From: Joanne Lewis <Joanne.Lewis@arun.gov.uk>
Sent: 30 April 2021 11:59
To: Planning.Responses <Planning.Responses@arun.gov.uk>
Subject: RE: Planning Consultation on: BN/41/21/DOC

I refer to the application to discharge condition 7-acoustic assessment. I have reviewed the submitted report and have a number of questions concerning the data provided. I cannot recommend discharge of this condition until the following questions have been addressed;

Application No: BN/41/21/DOC
Registered: 6th April 2021
Site Address: Tars Farm Church Lane Barnham PO22 0DB
Description of Works: Approval of details reserved by condition imposed under BN/39/20/PL relating to conditions 6-surface water drainage, 7-acoustic assessment & 14-detailed level survey.

Site Plan showing Measurement Positions (Appendix 2, Figure 1):

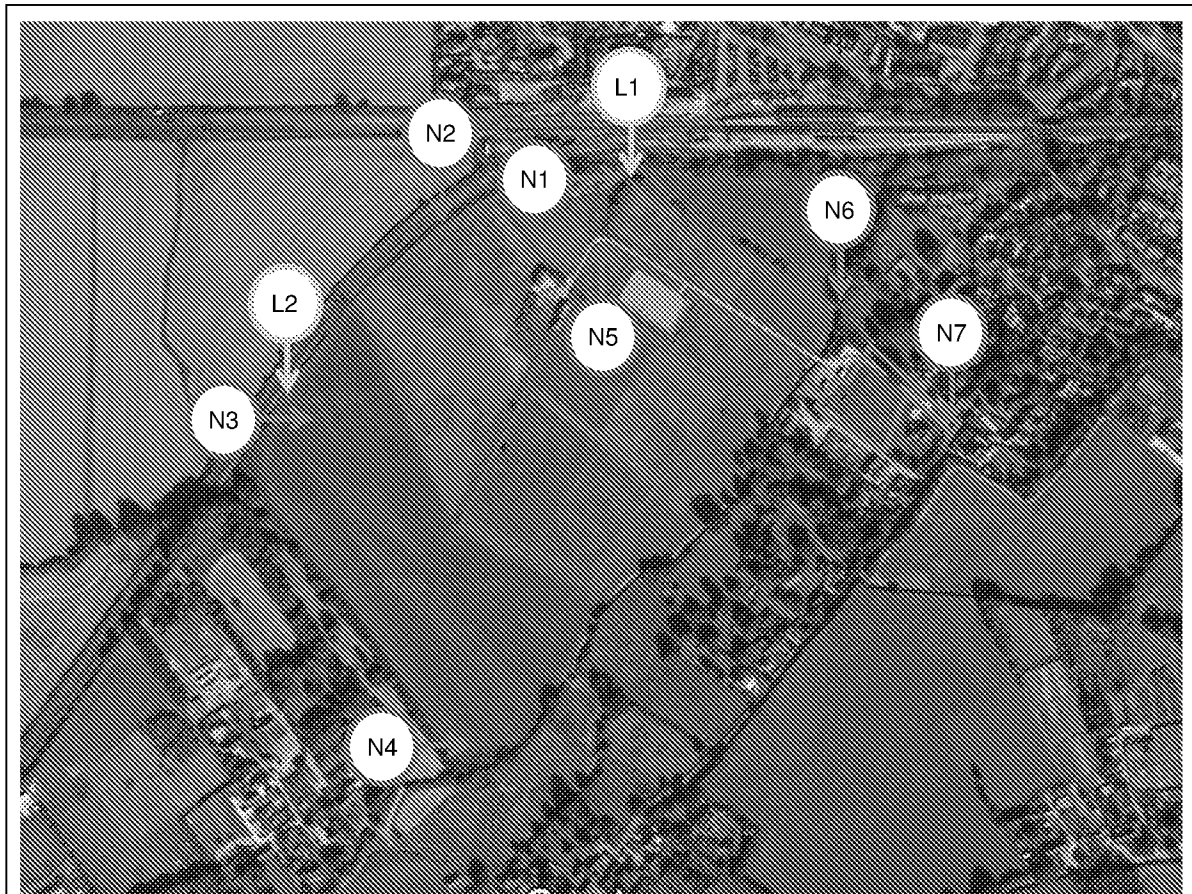
1. The noise measuring positions shown in Appendix 2, Figure 1 appear to show that very little noise monitoring was actually carried out on the site concerned. N6 and N7 are the closest but not on what I would consider to be likely to be the most affected area of the site. Please can an explanation be provided as to why limited monitoring was actually carried out on site.

2. The closest measurement locations N7 and N6 were attended noise monitoring which was carried out for 4 mins at each location. Please can an explanation be provided as to the very limited noise monitoring that was carried out here.
